Rezoning Transportation Analysis

Petition Number: 2020-157

General Location Identifier: Tax ID: 07106117

Date	Description
11-30-20	First Review (EL)
12-28-20	Second Review (EL)
01-26-21	Third Review (EL)

REZONING PETITION
#2020-157

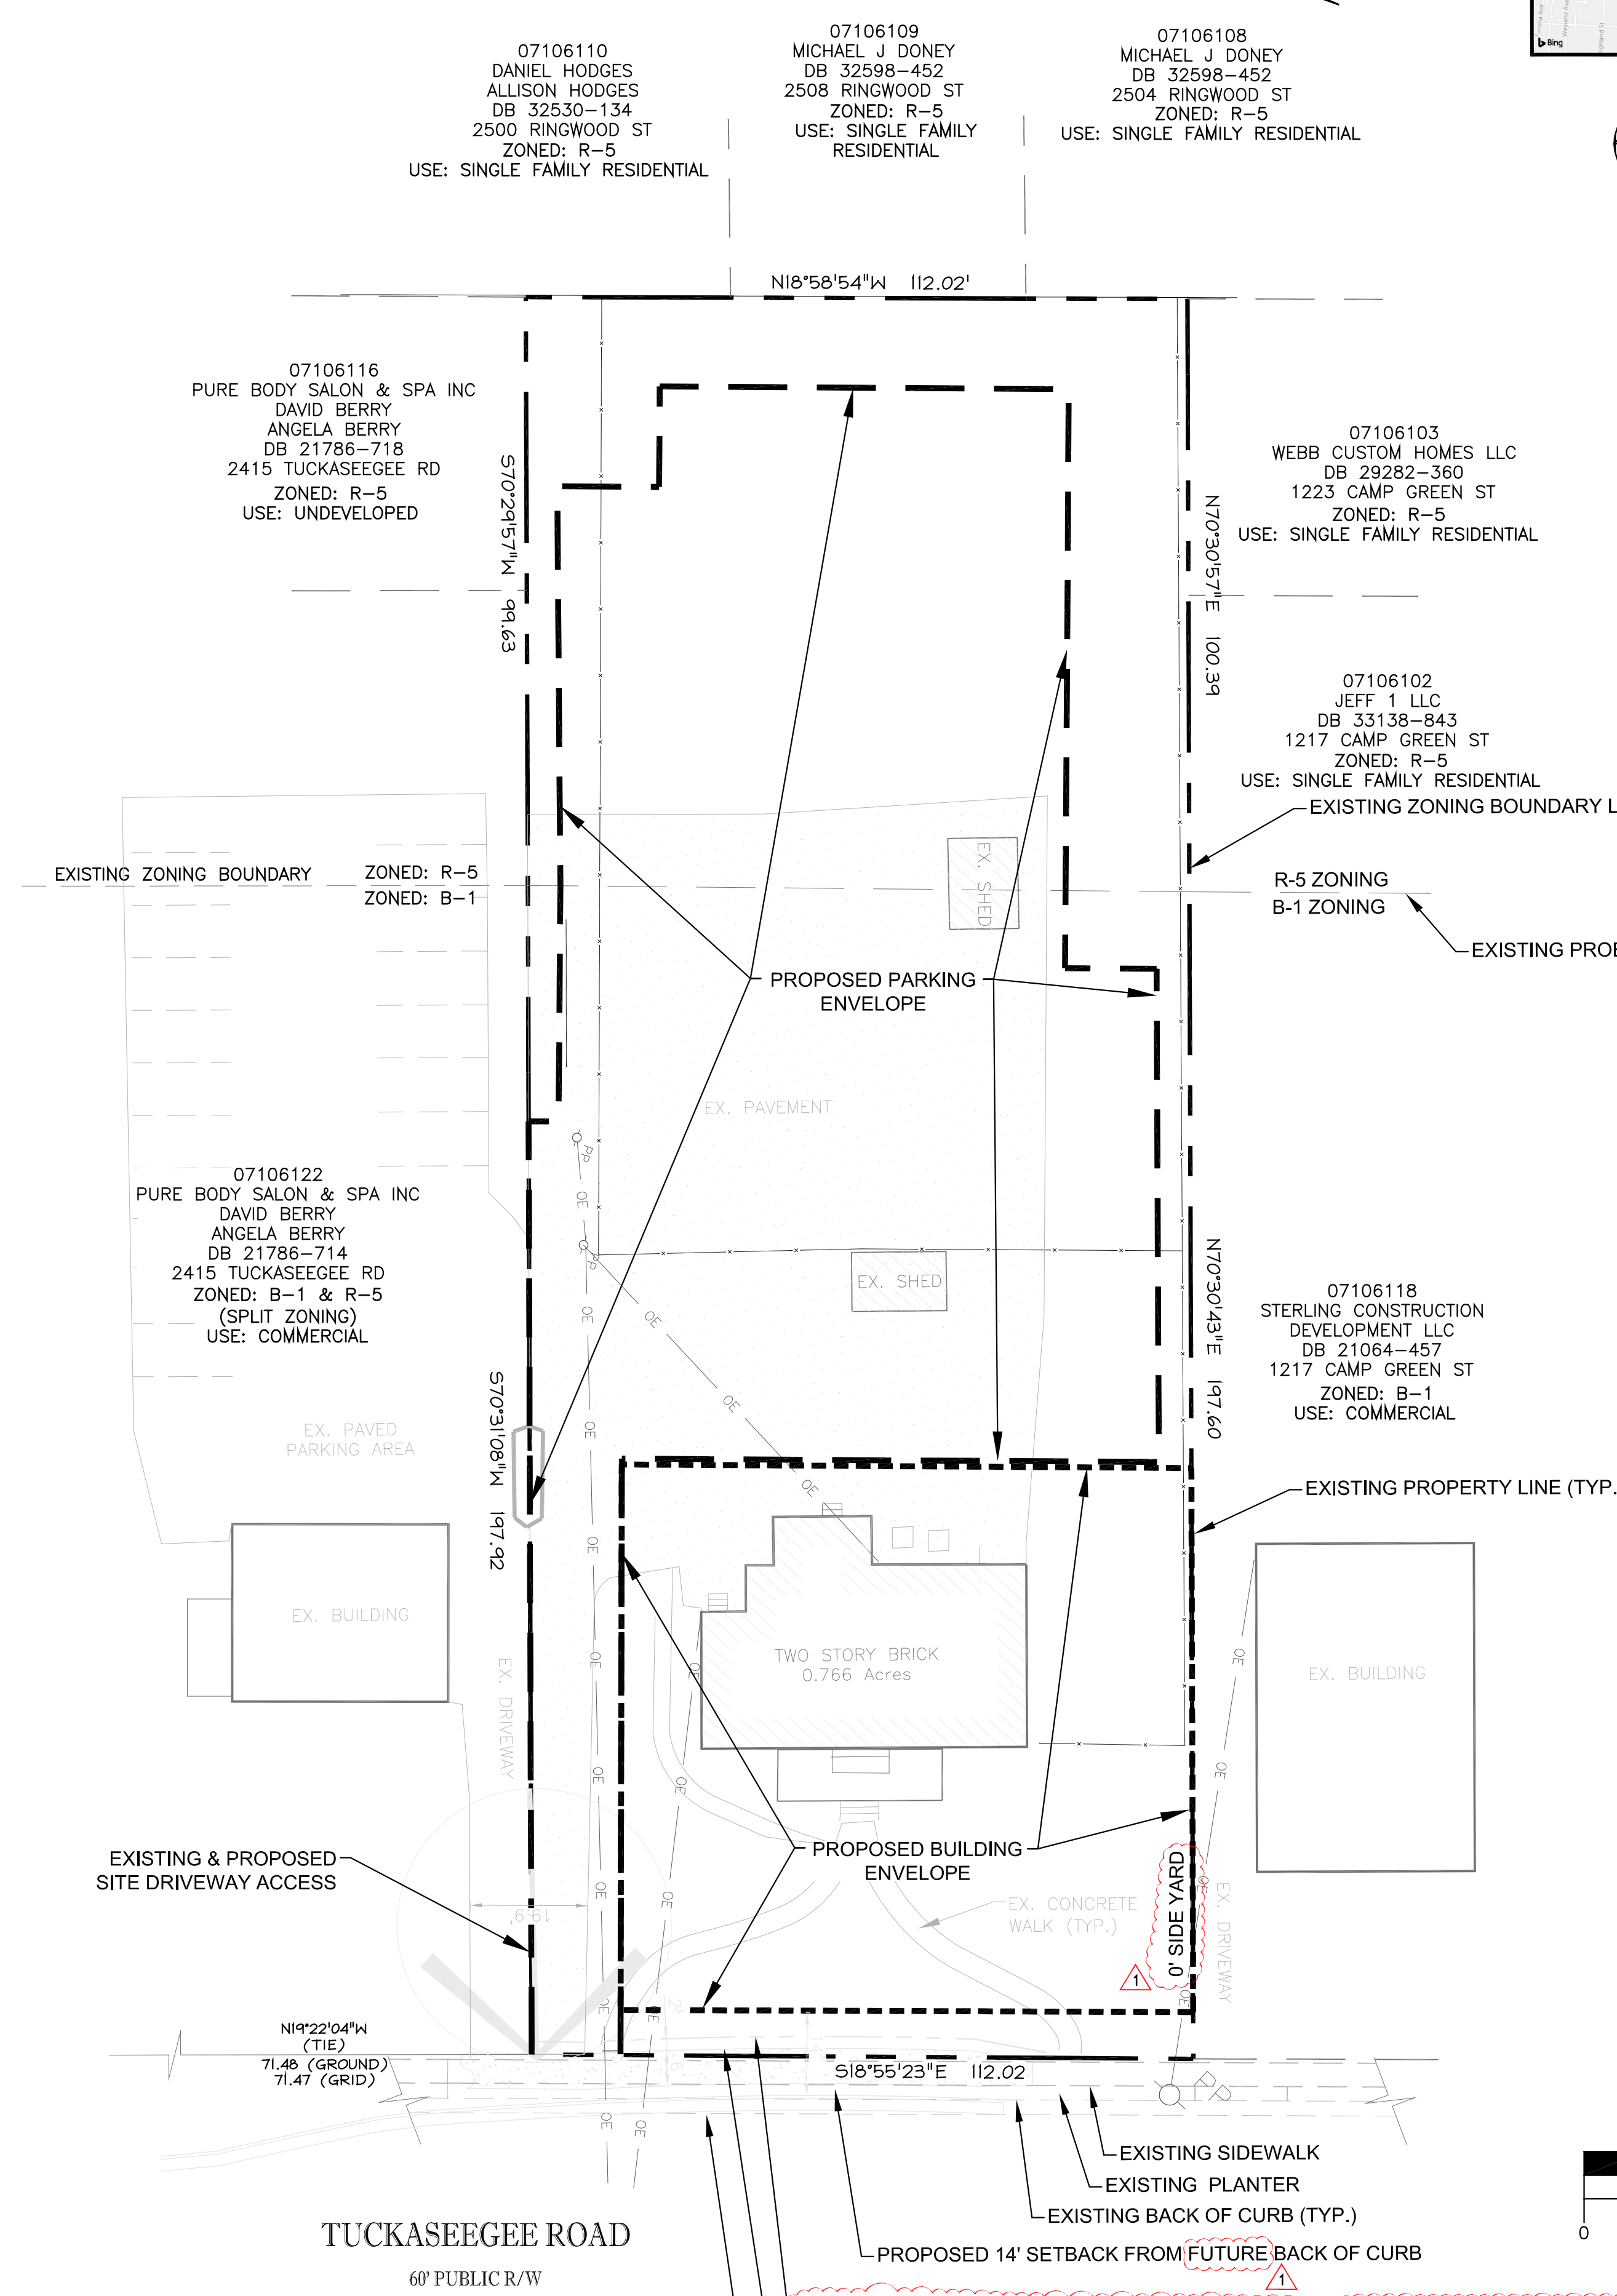
4. **Outstanding comment (site plan dated 12.15.2020):** Revisions are needed on the site plan and conditional note (Section 7.B) to relocate the proposed 8-foot planting strip to the Tuckaseegee Road back of curb, separating the proposed 6-foot sidewalk from the roadway, as required within Chapter 19-174 of the City Code, to allow the planting strip to function as necessary.
